Add COM-2222

RE: James Irwin Charter School
Traffic Technical Memorandum
El Paso County, Colorado
LSC #224370

Figure 1
Vicinity Map

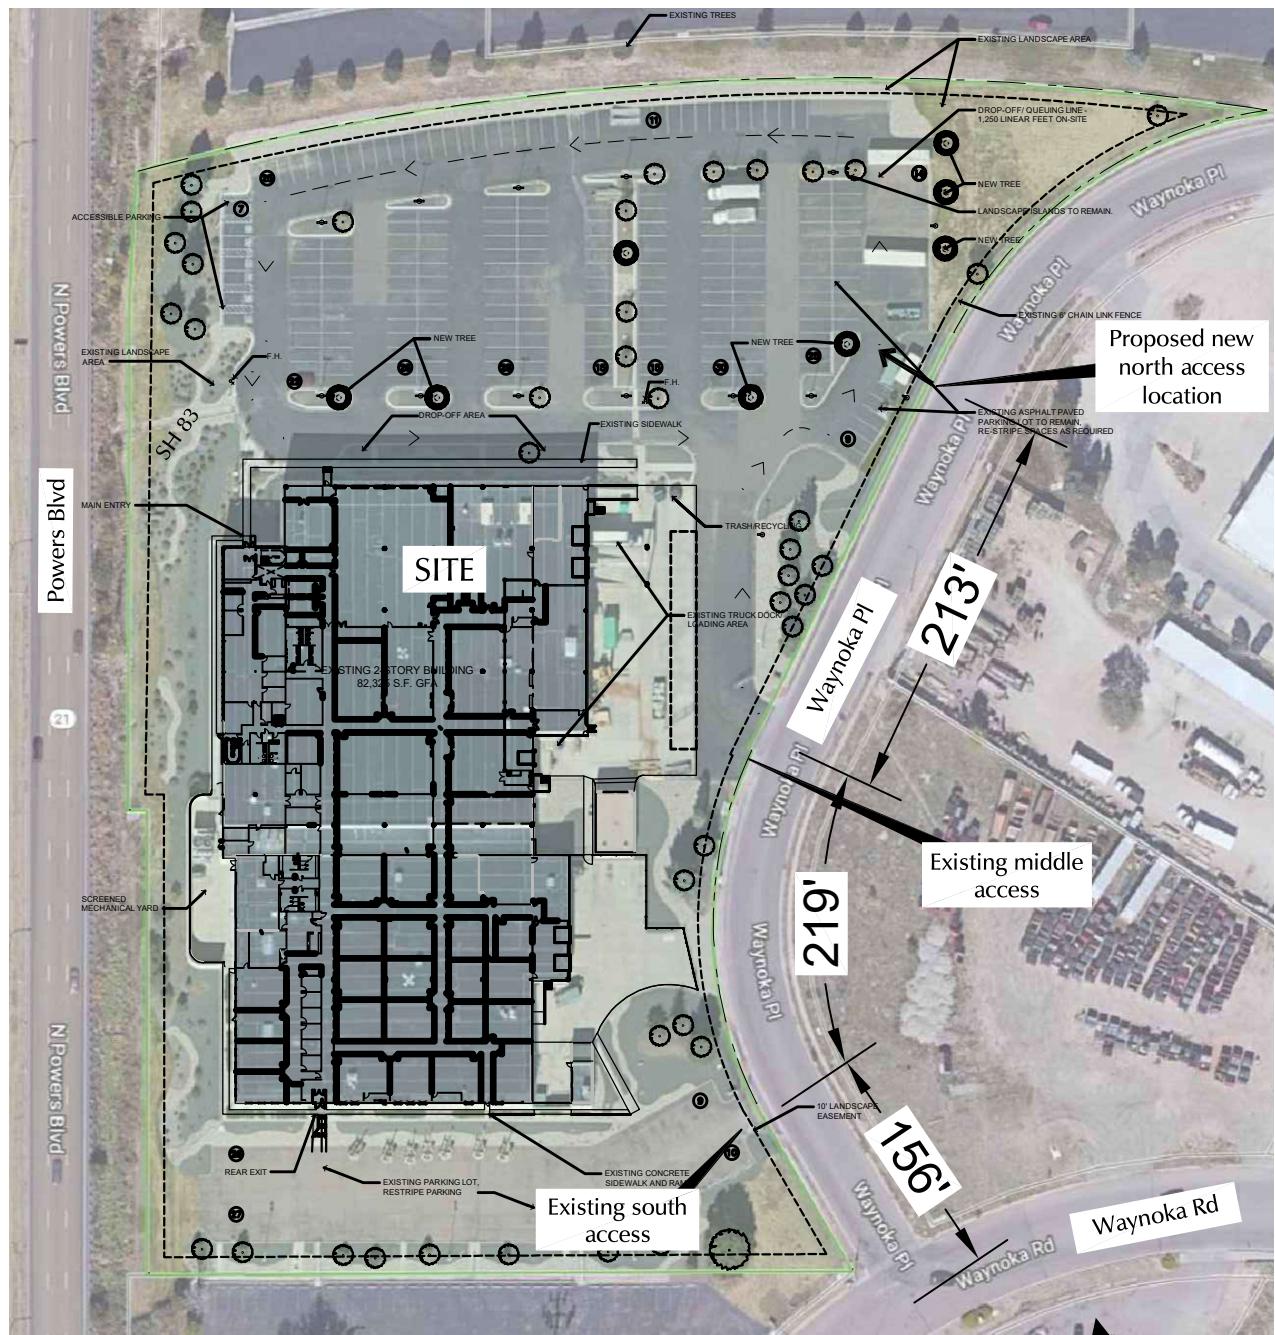
It appears figure 1 is a vicinity map. Figure 4 shows directional distribution for the area. Please describe in the narrative what zip codes students are expected to travel from.

Site Plan

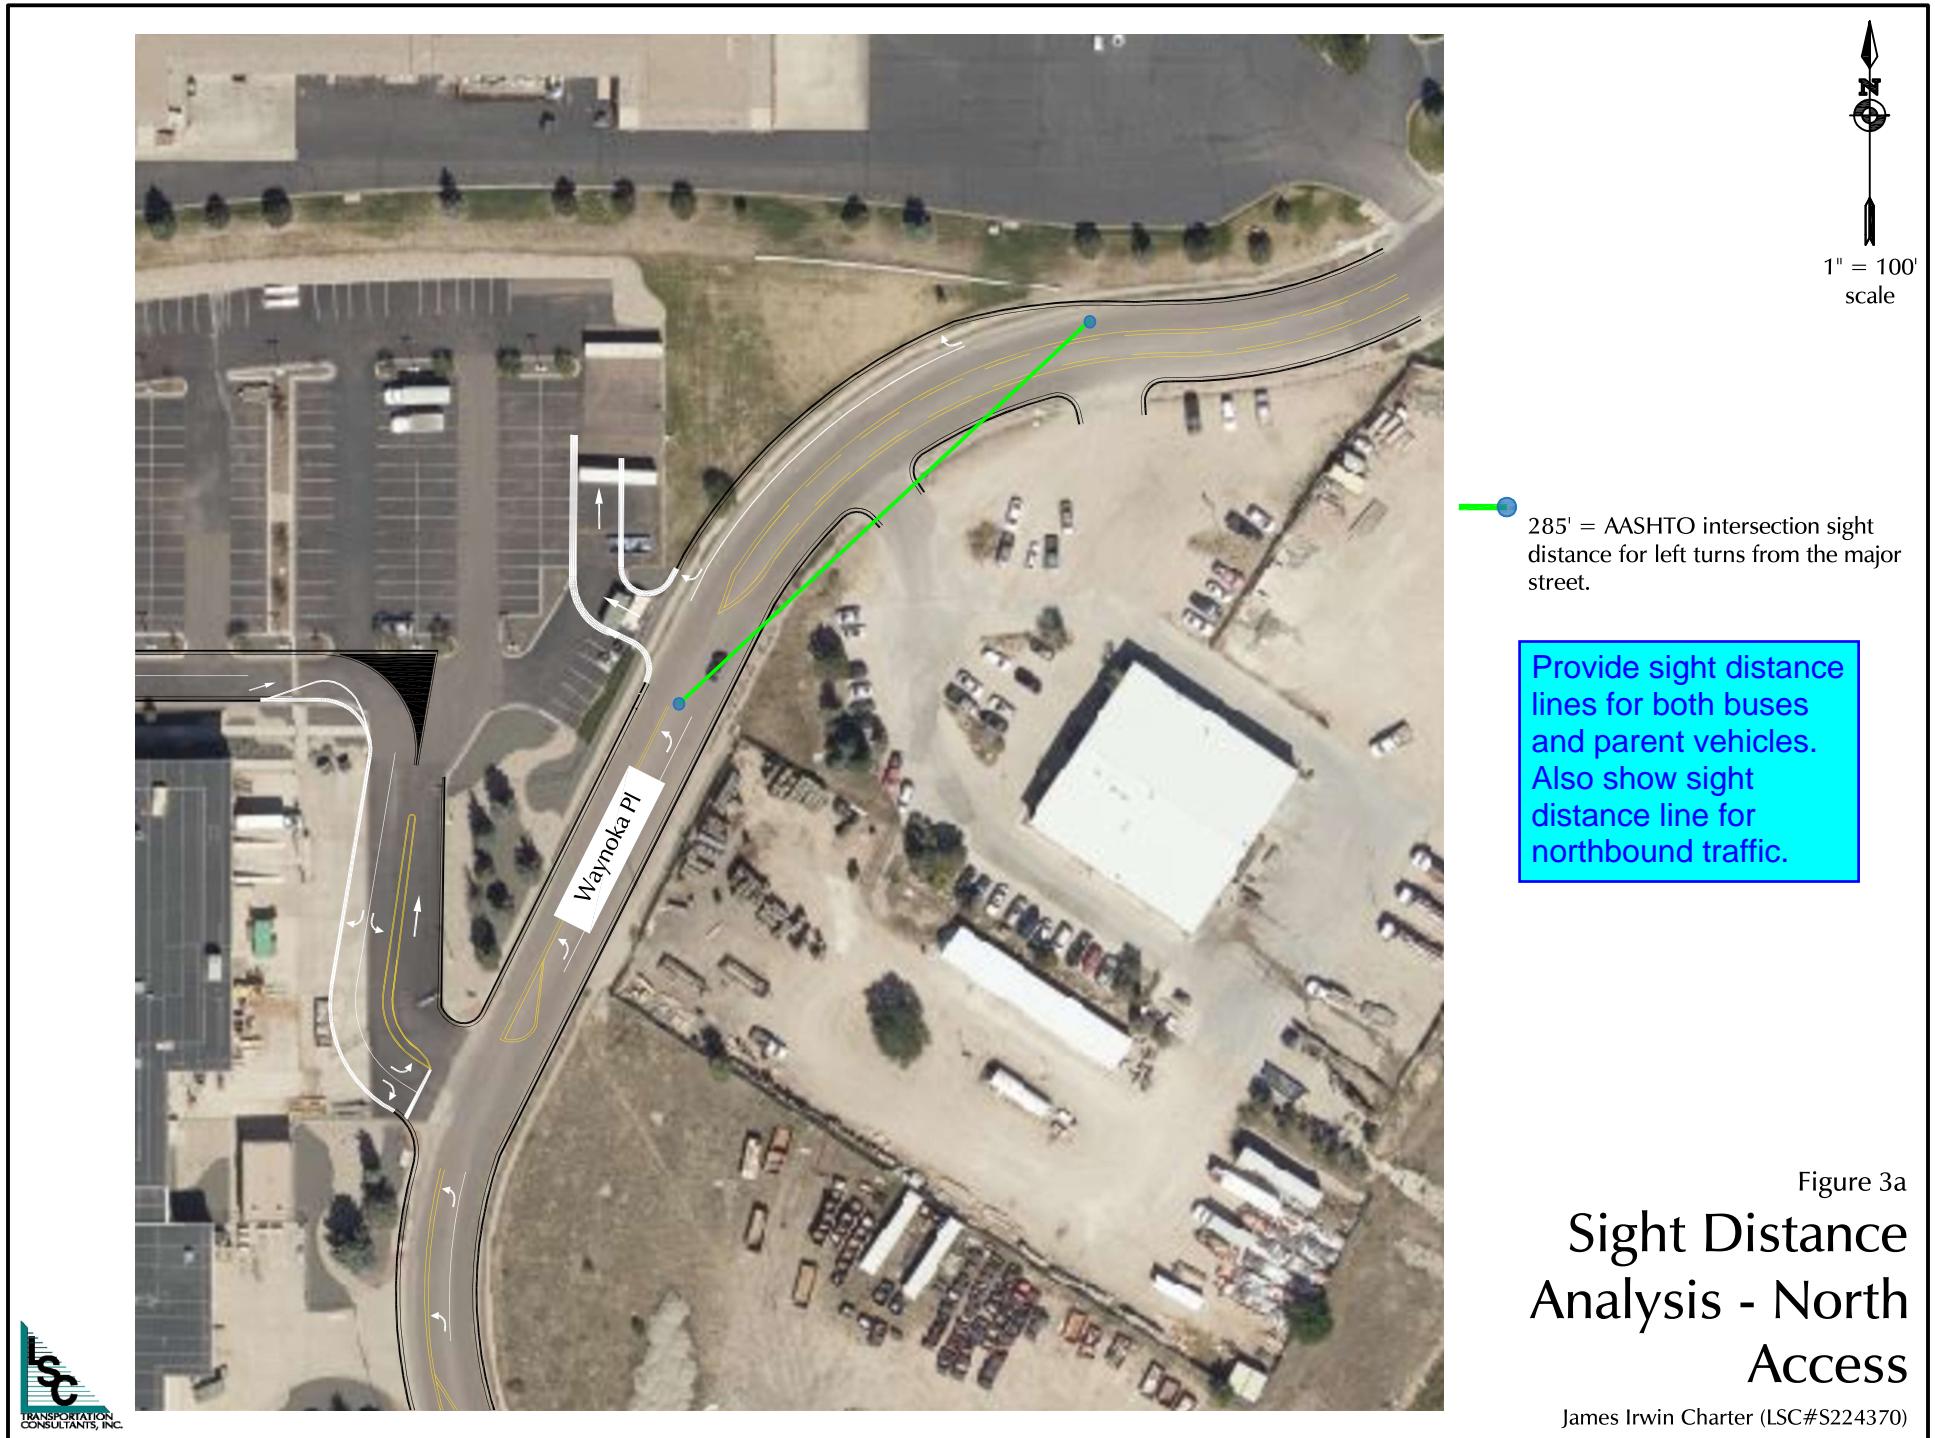
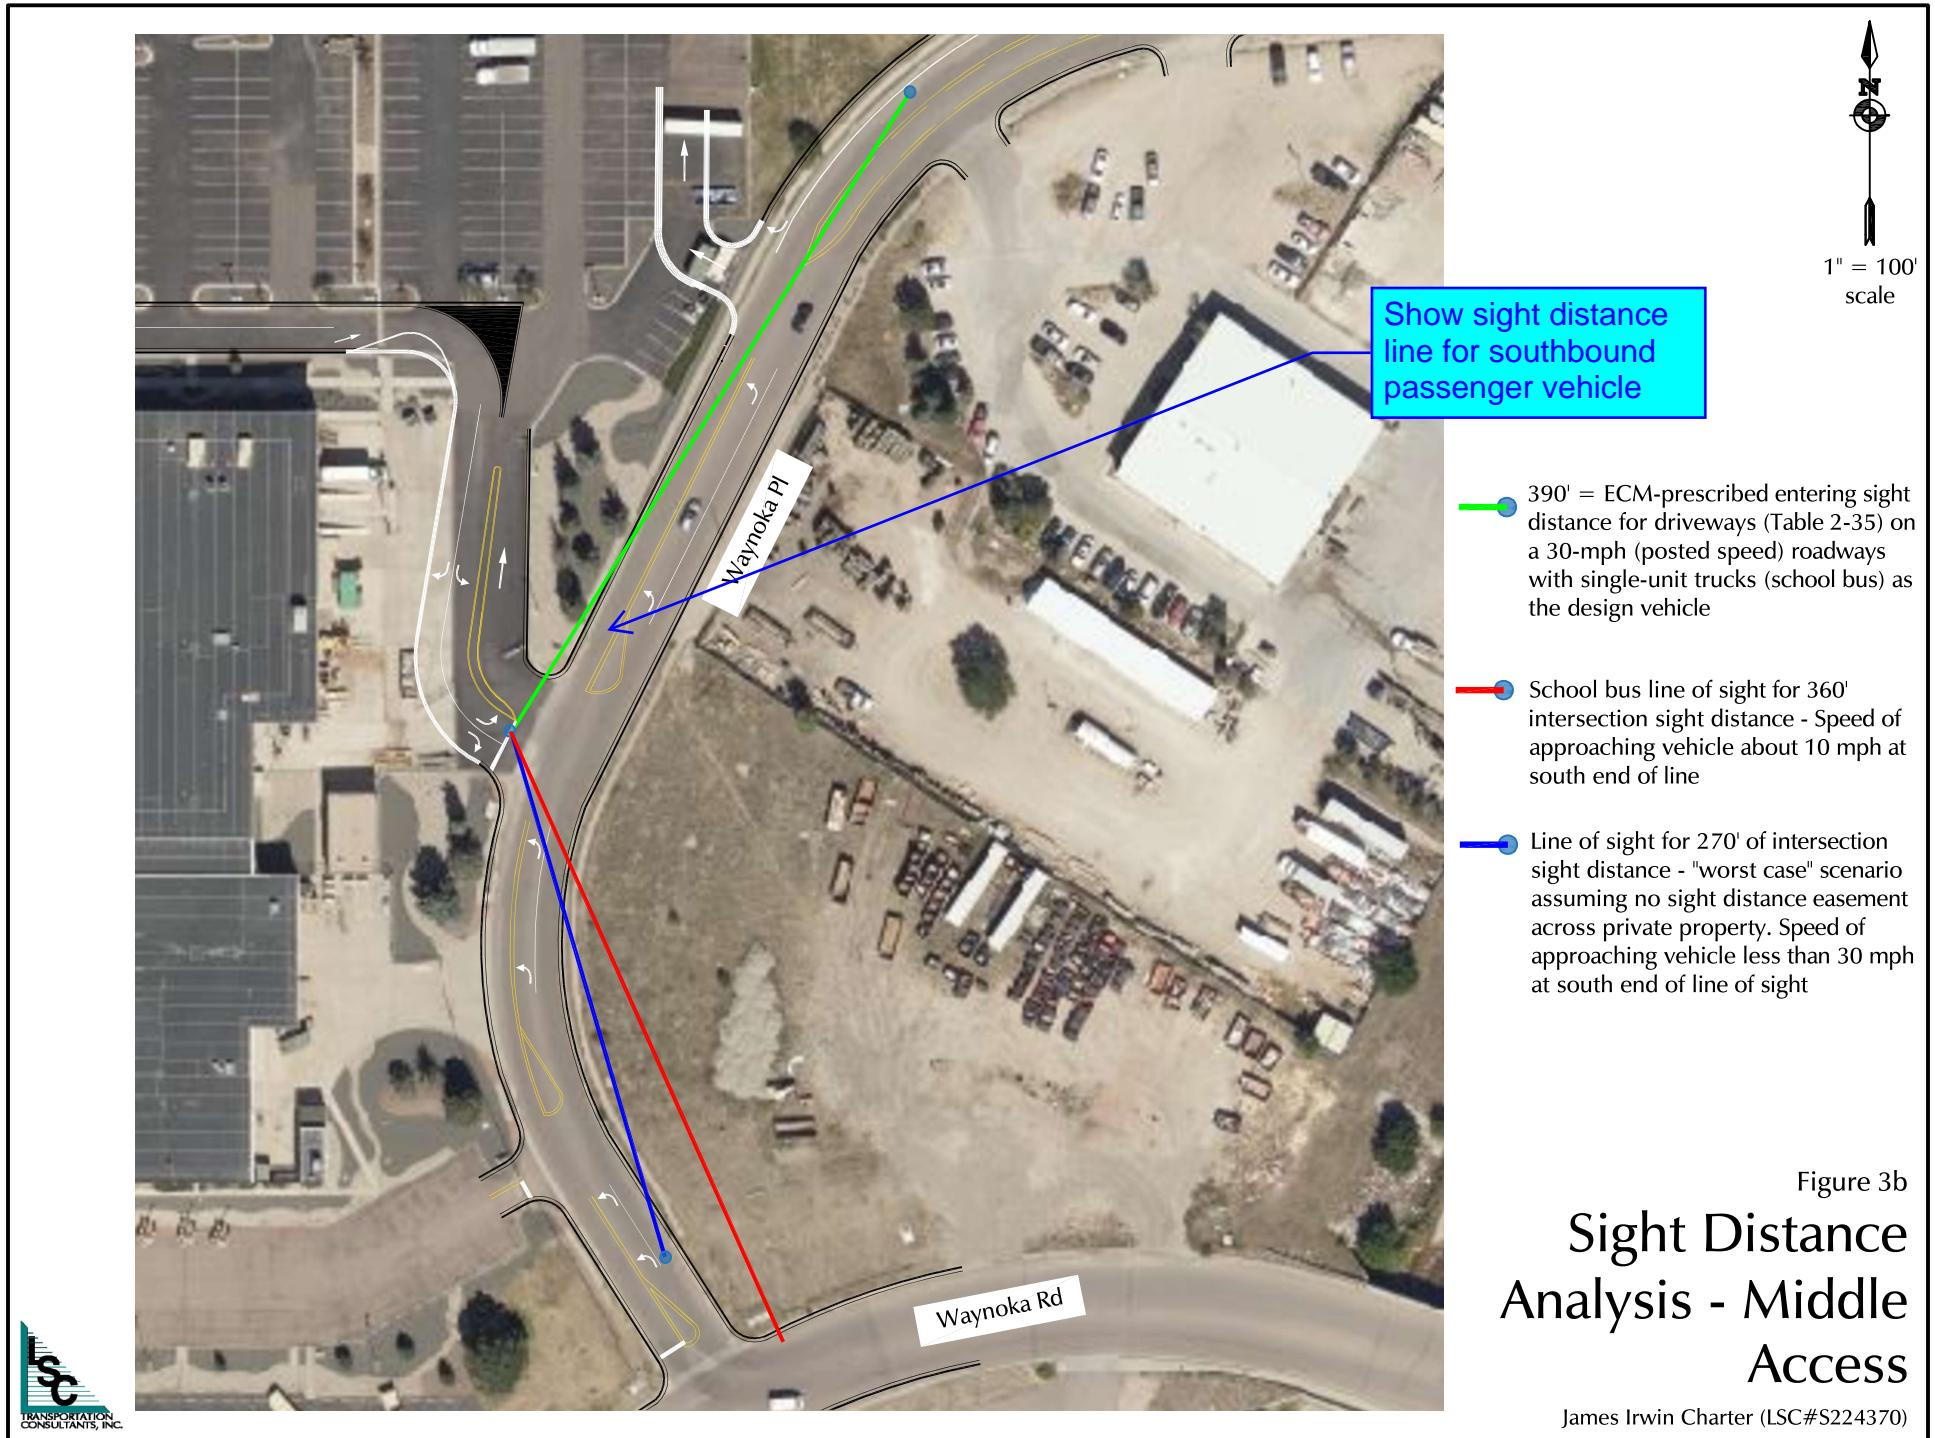
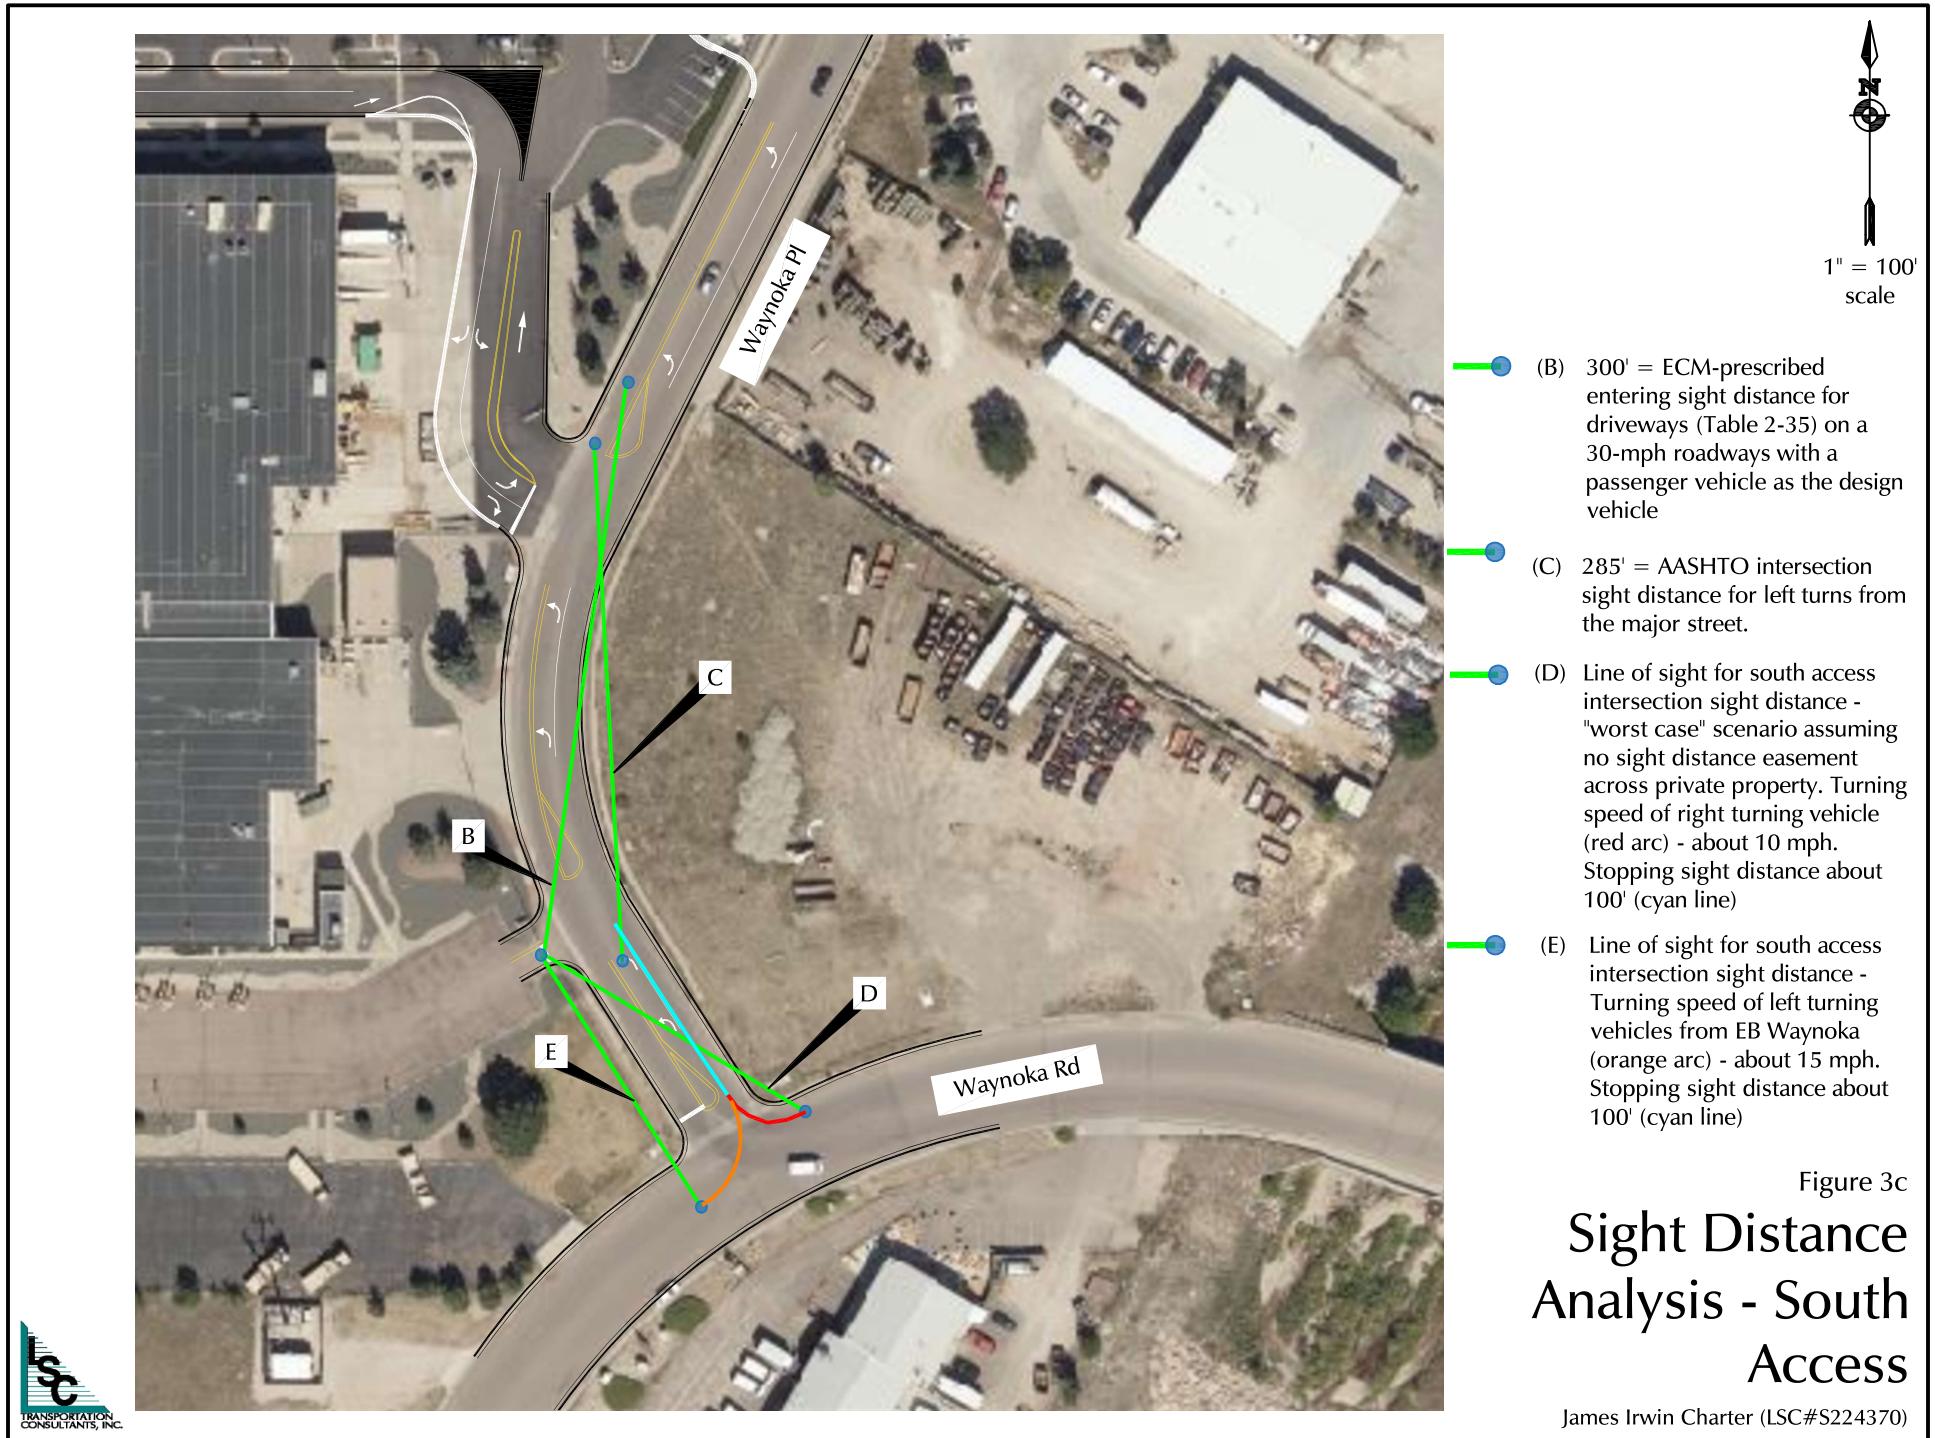
Site development shows 470' of drop-off length. Provide recommendation of stacking length so cars do not back into road.

Staff recommends providing additional stacking distance to avoid cars backing up into Waynoka Place. Per City of Colorado Springs 1800 feet is more appropriate.
